Recommendation Report for Planning Permission for Works or Extension to a Dwelling

REF NO: Y/19/26/HH

LOCATION: 7 Gladstone Road
Yapton
West Sussex
BN18 OJP

PROPOSAL: Single storey rear extension to replace existing conservatory.

GROUND FLOOR PLAN ~ AS PROPOSED

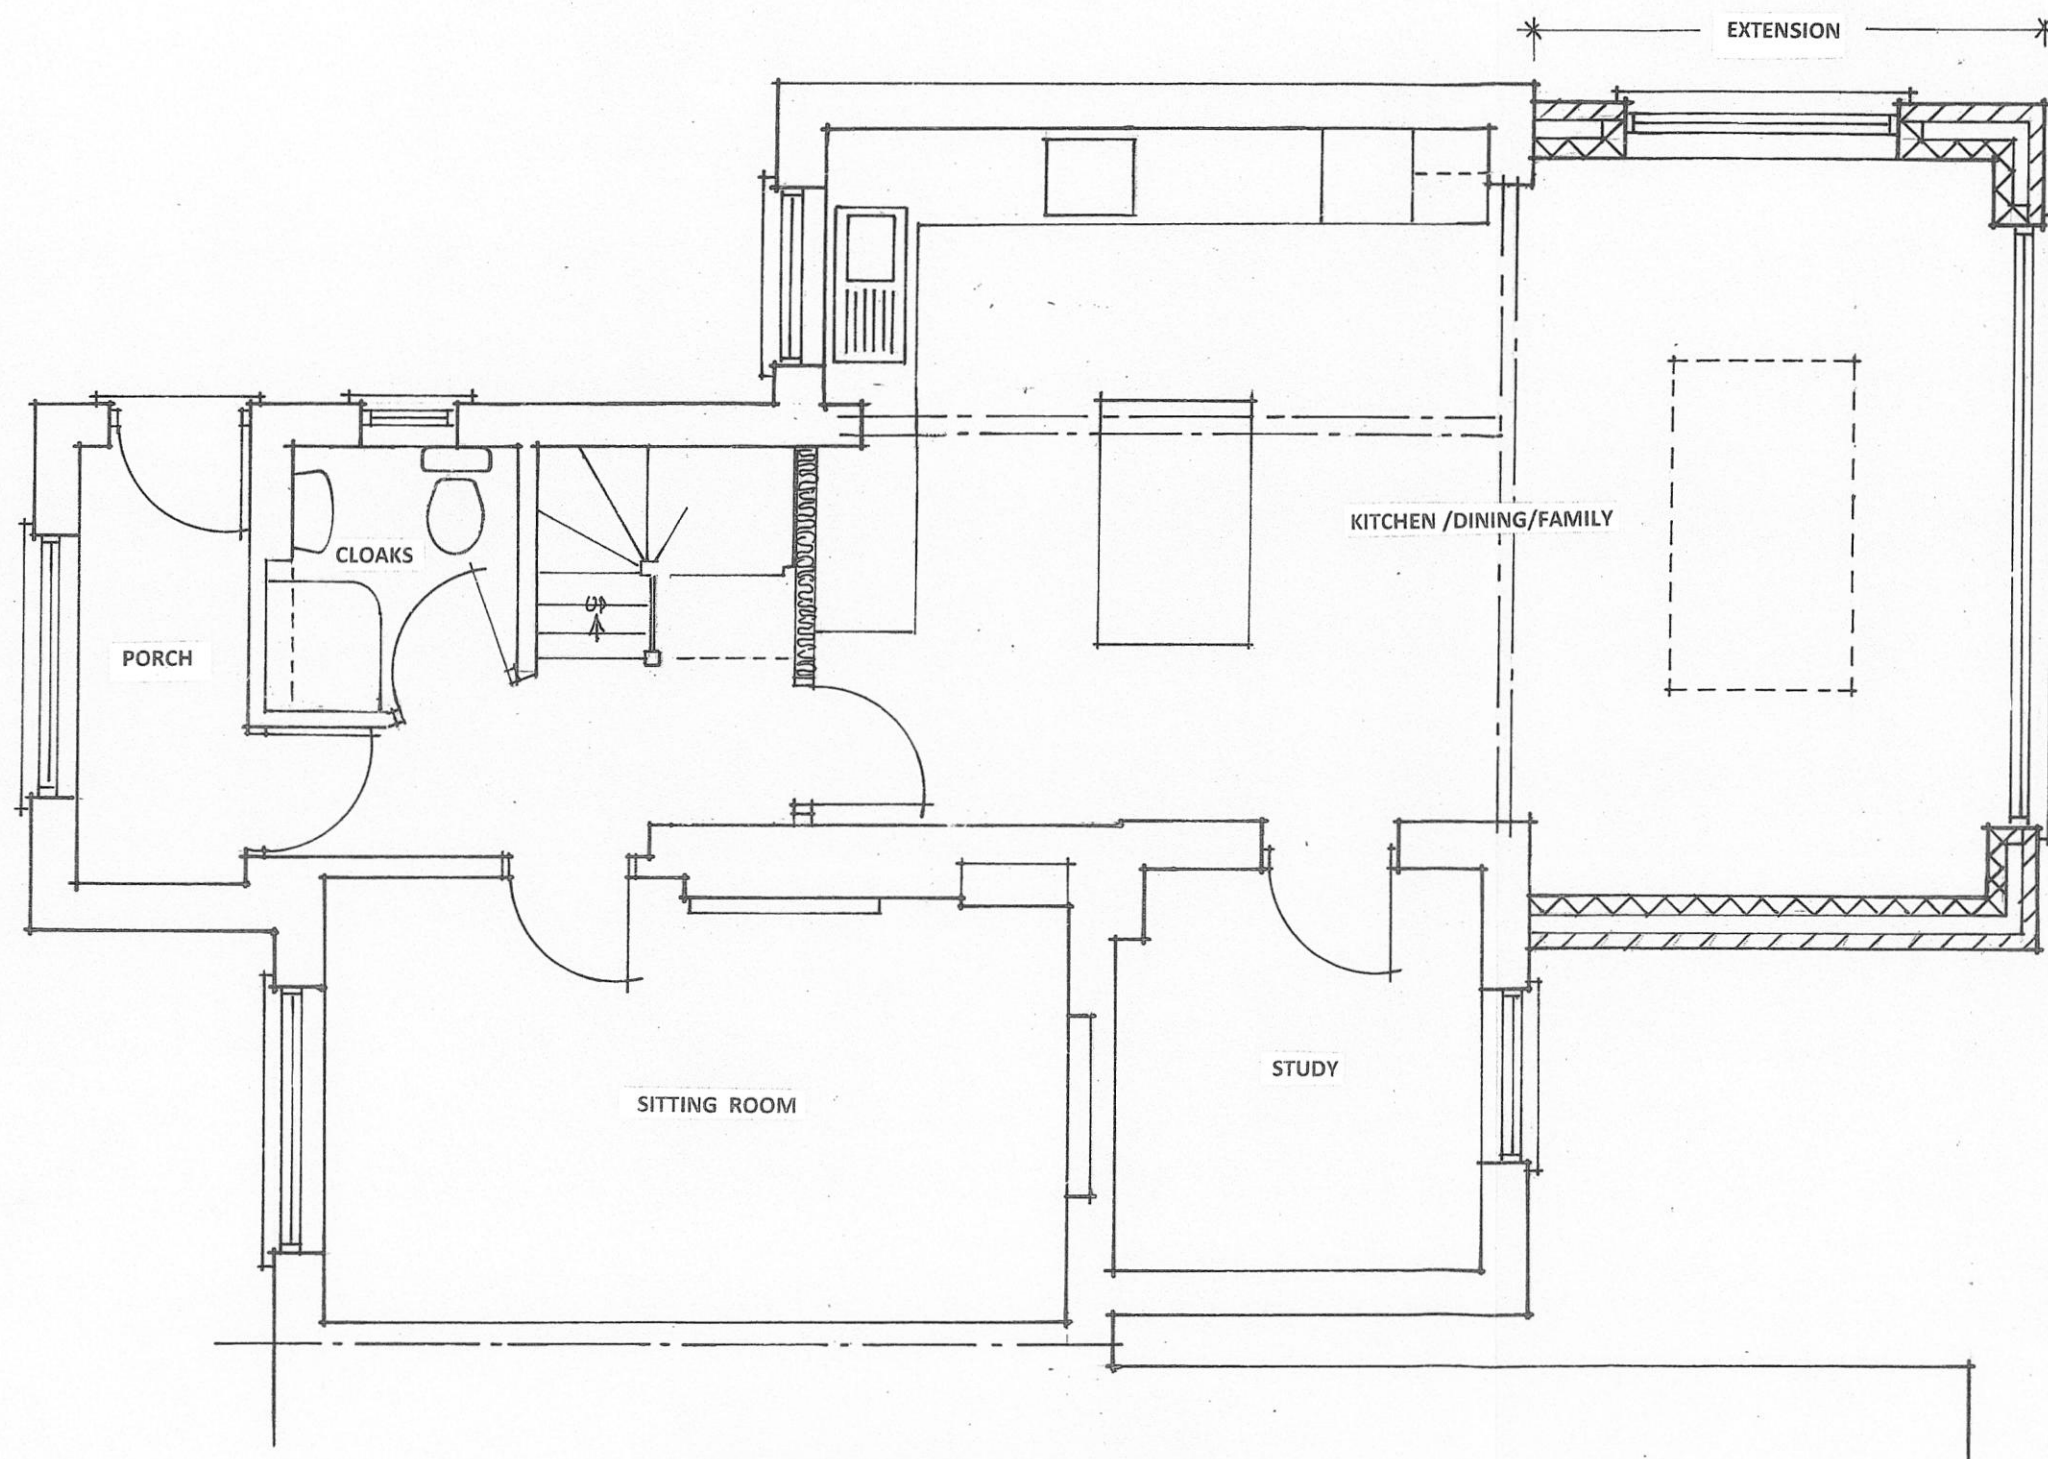
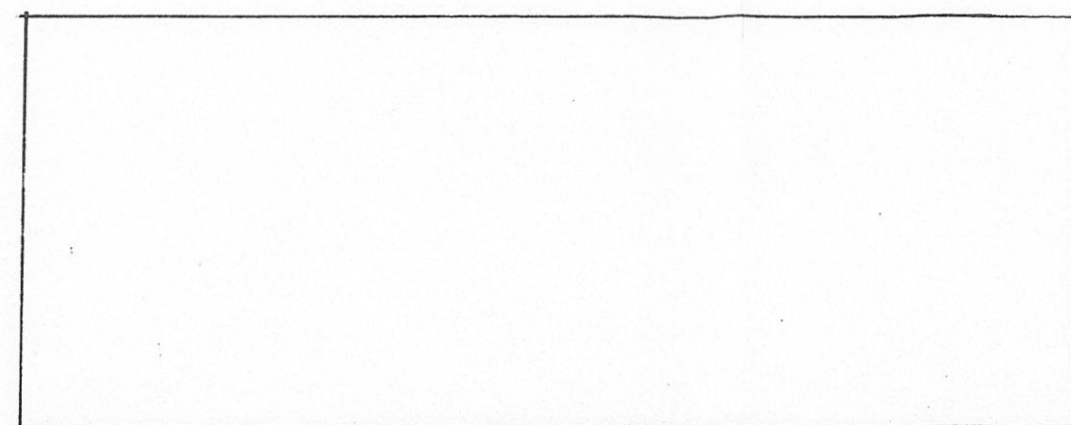
The extension would have a width of 5.6m, extending 0.6m further than the existing conservatory, constructed to the rear elevation, to the north. The extension would be have a depth of 3.4m, 0.4m greater than the existing conservatory. Whilst this would, albeit marginally, exceed Arun Design Guide advice for rear extensions which advises a maximum depth of 3.3m, given the existing built form and policy compliant rear garden depth of 24.5m, the proposal would not result in harm to design or visual amenity in this regard.

At 3.2m in height, the proposed extension would be equal in hight to the ridge of the existing conservatory. However, the introduction of a flat roof as opposed to the existing pitch roof of the conservatory would result in a bulkier, more imposing form. The flat roof would include a roof lantern, as well as sliding doors with a width of 4m, responding well to the open, spacious character that the conservatory contributes towards.

ROOF PLAN ~ AS PROPOSED

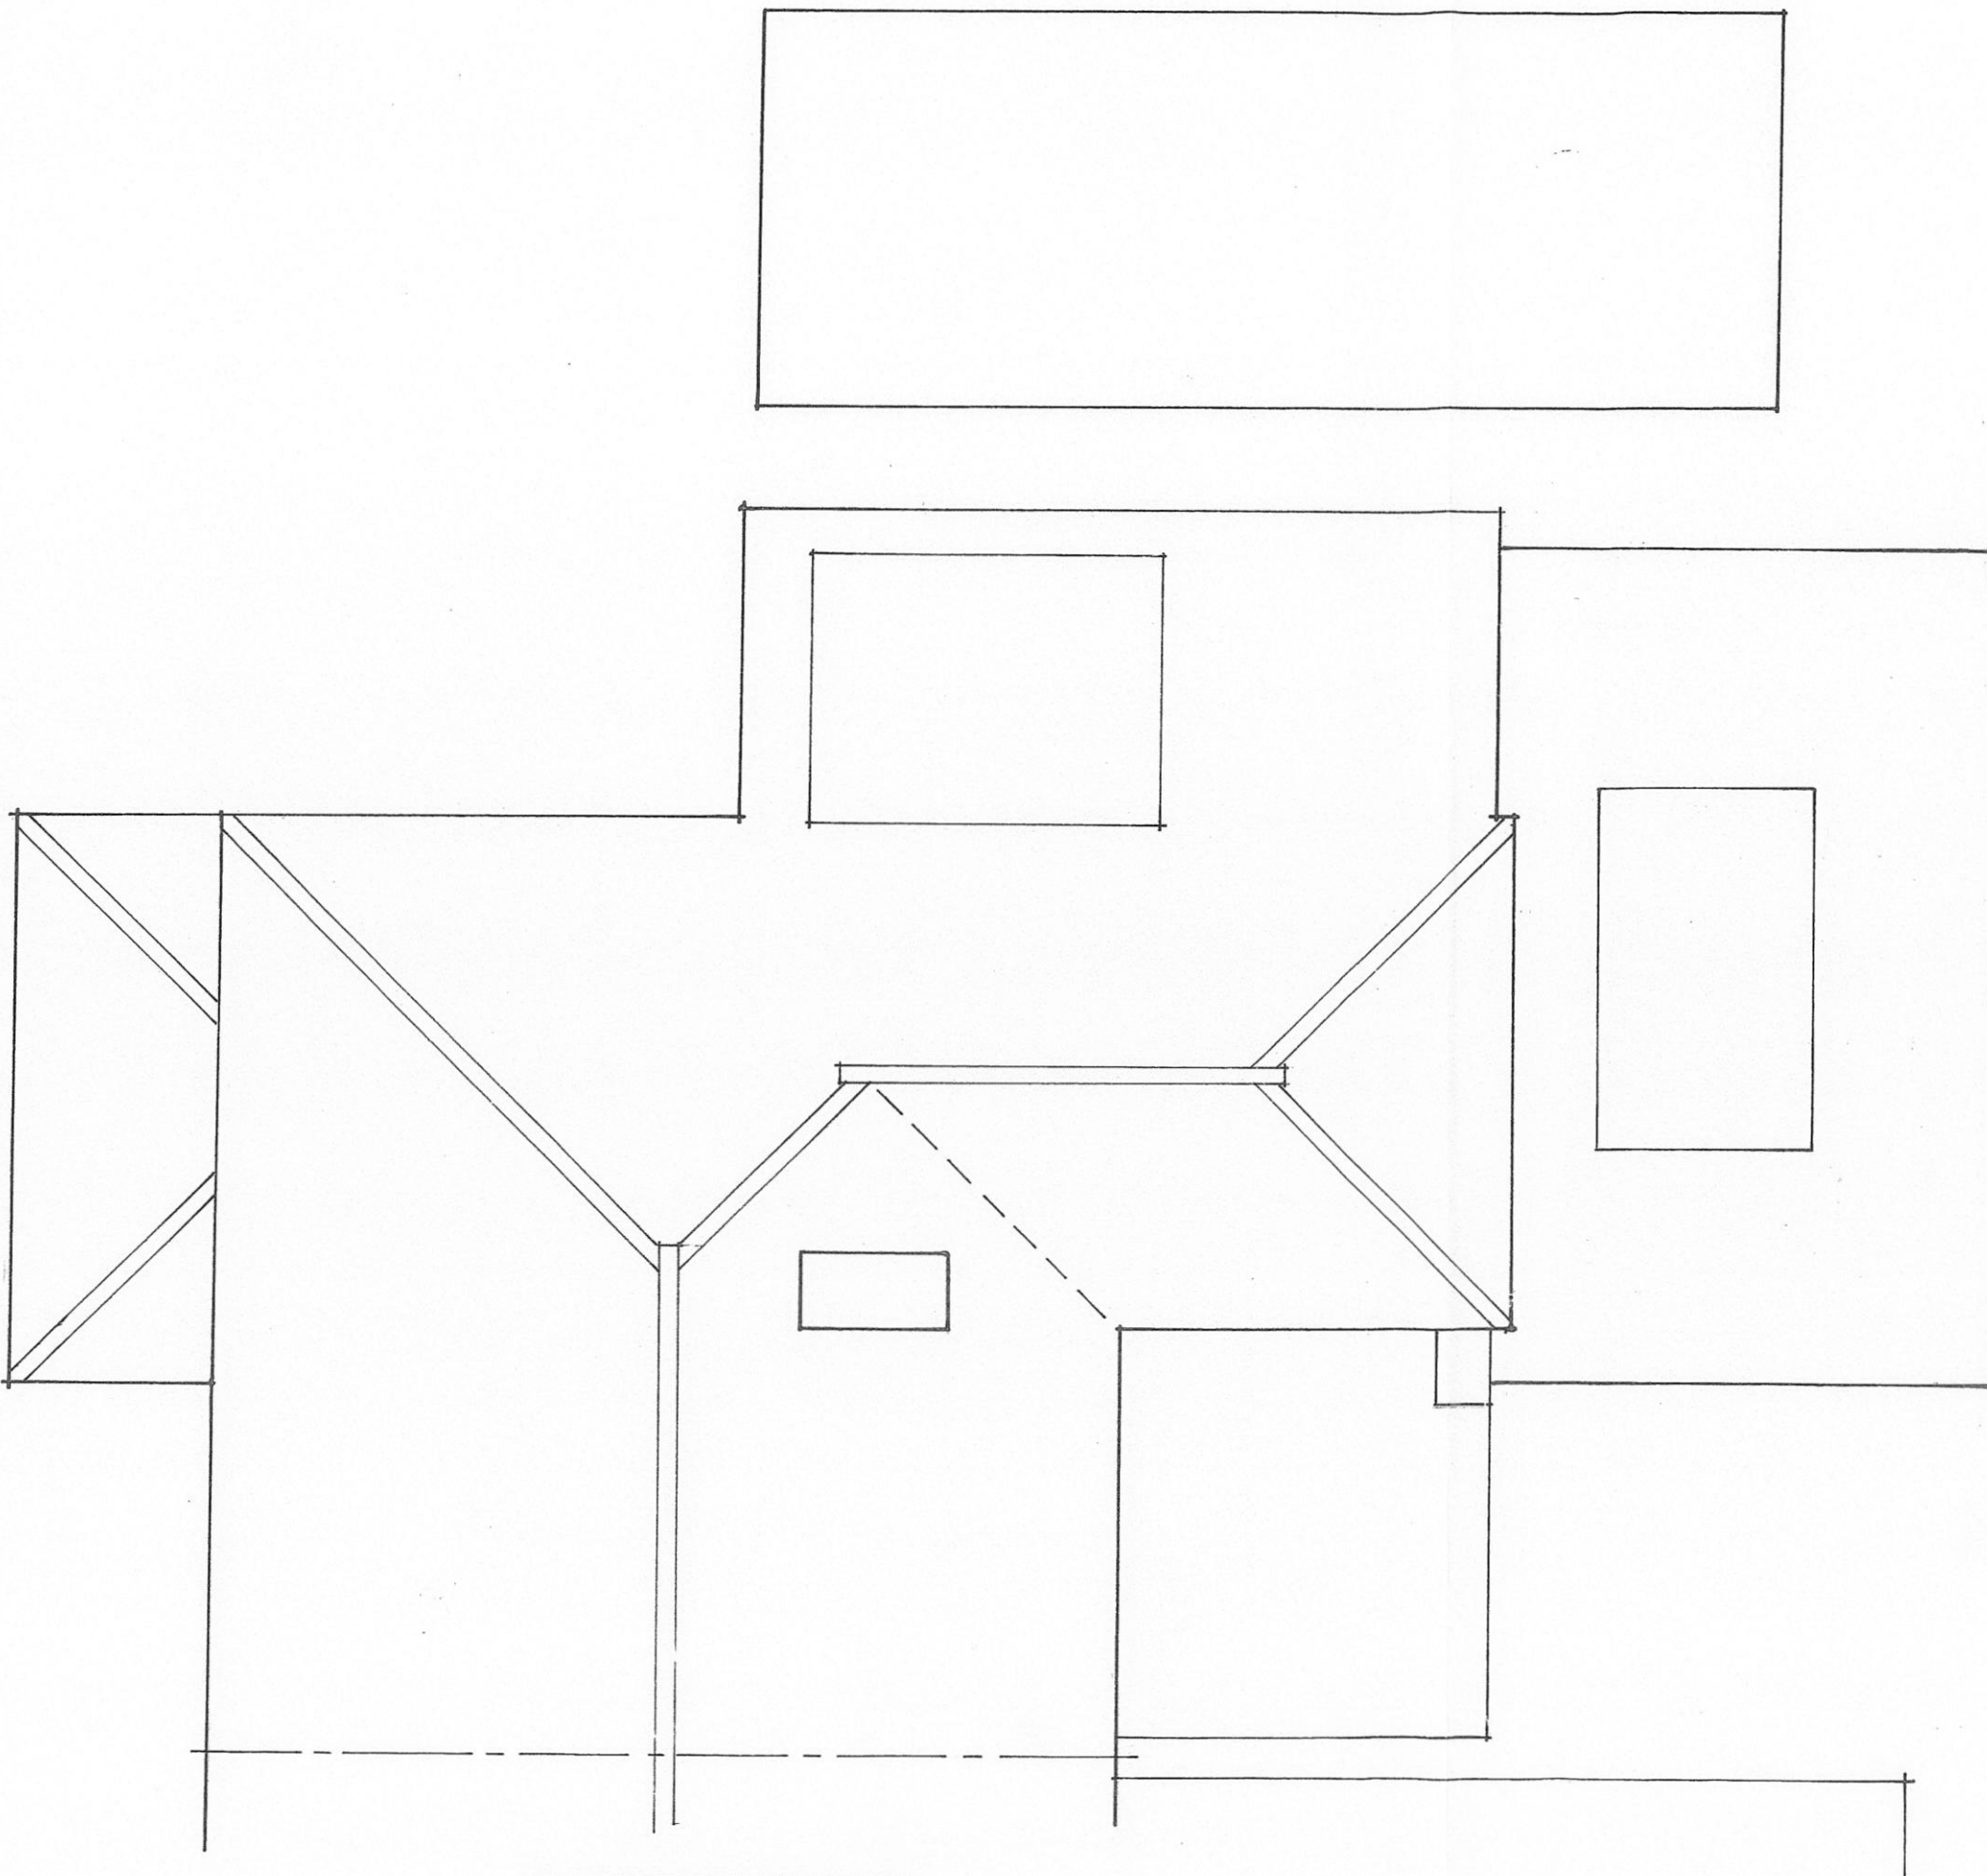
Flat roofs, with roof lanterns and roof lights, are very common along Gladstone Road, utilised for both extensions and garages; the proposal would be in keeping with the existing architectural form in the locality. In terms of materials, the brickwork, aluminium doors and white UPVC windows would be of no detriment to design and visual amenity and would integrate well with the host dwelling.
